**Canal &
River Trust**

Your Ref 2023/92444

Proposal: Discharge of conditions 4 (highway retaining walls) and 5 (river adjacent retaining wall) of previous reserved matters approval 2022/90890 for matters of layout, appearance, scale and landscaping pursuant to outline permission 2019/92221 for demolition of existing buildings and erection of Class E retail unit, access, car parking, servicing, landscaping and associated works

Location: Kenmore Caravans Ltd, 119, Huddersfield Road, Mirfield

Drawing Title: **Sheet Piling - Installation GA Drawing and Details**

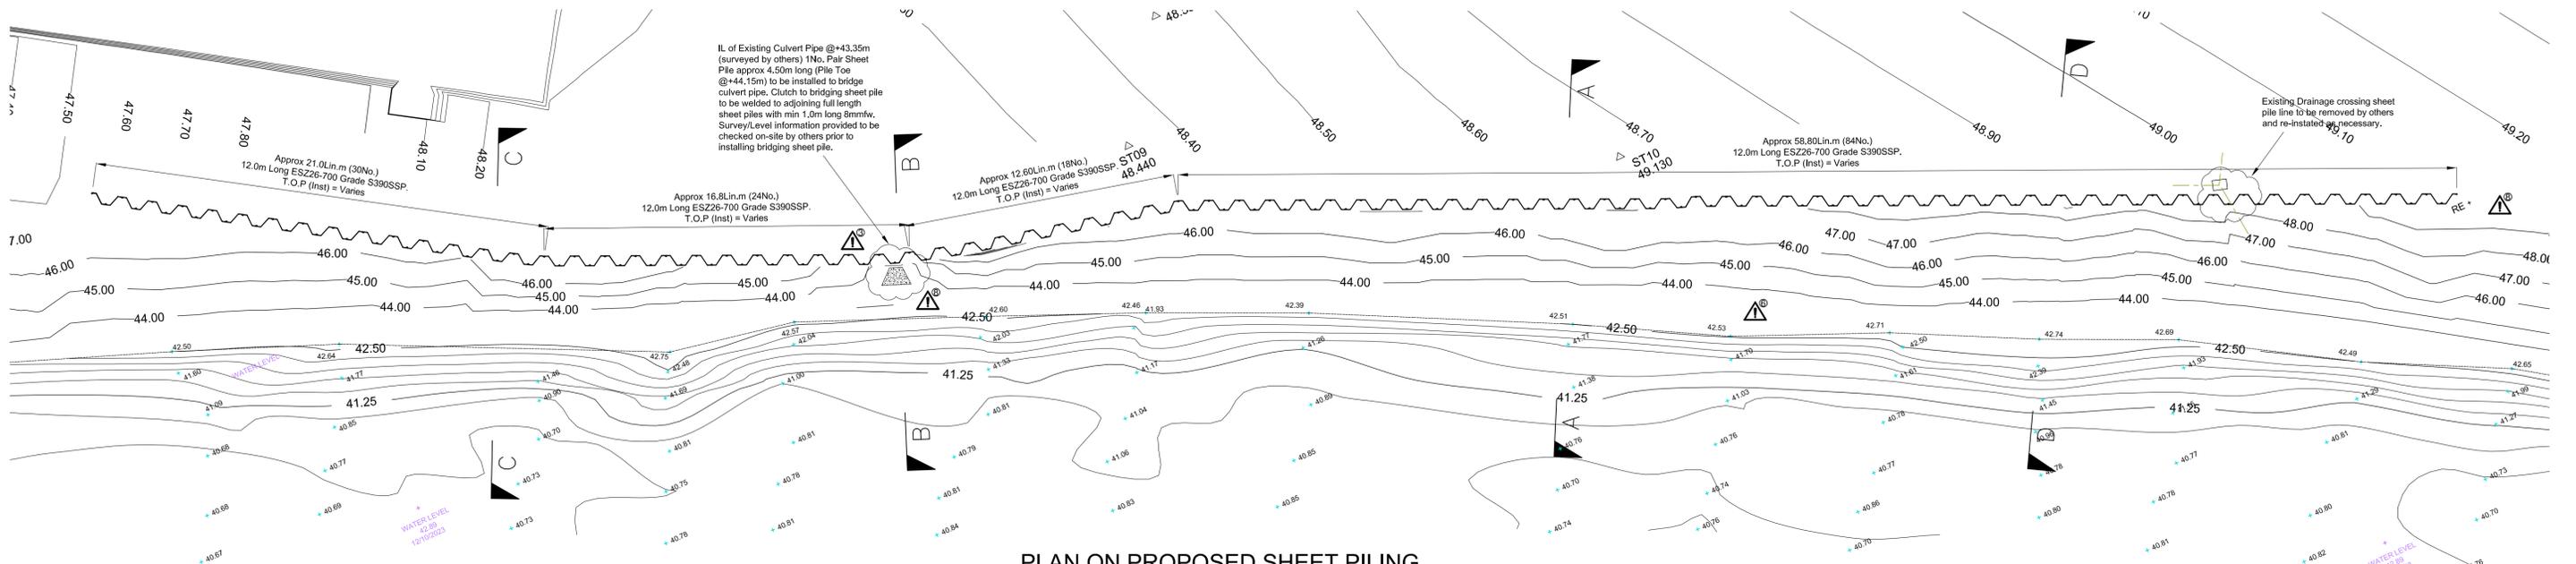
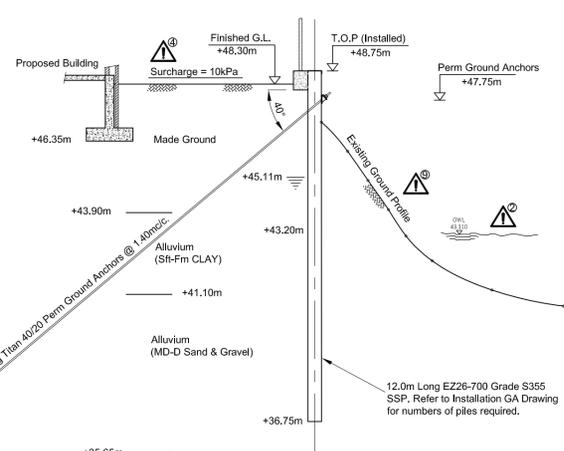
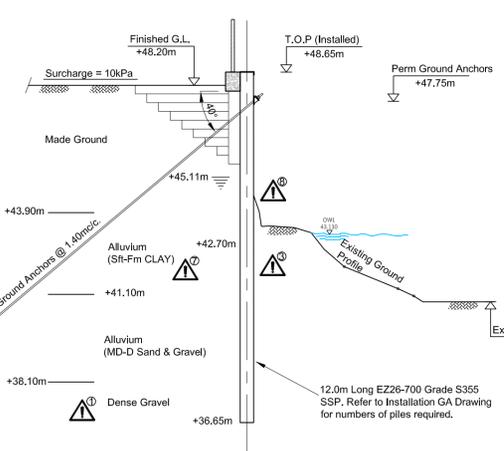
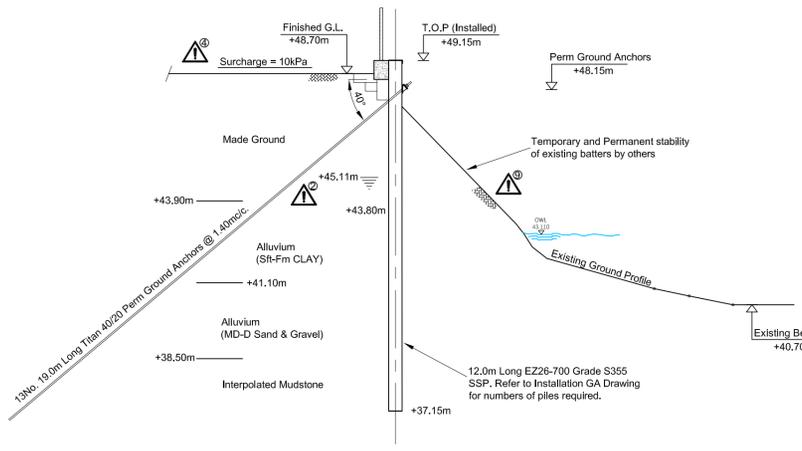
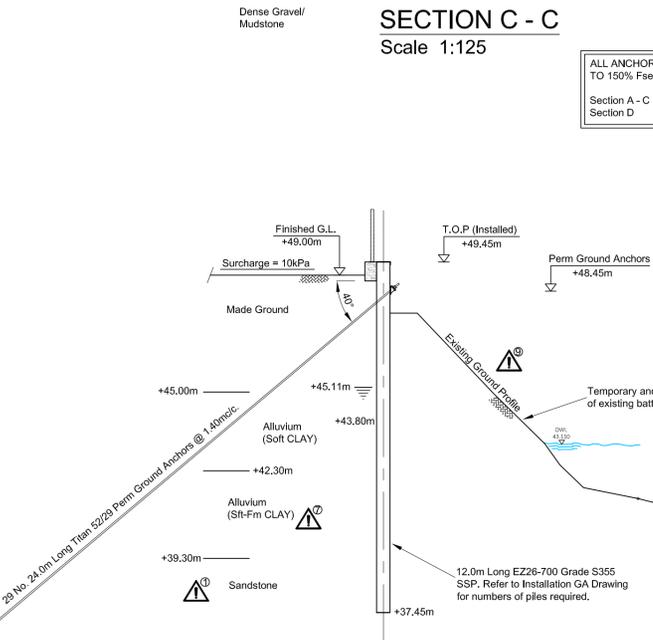
The Trust is satisfied that the piling works provided are appropriate to support the car park above the site. The cross sections also show upstand details to prevent water runoff from the car park to the waterway.
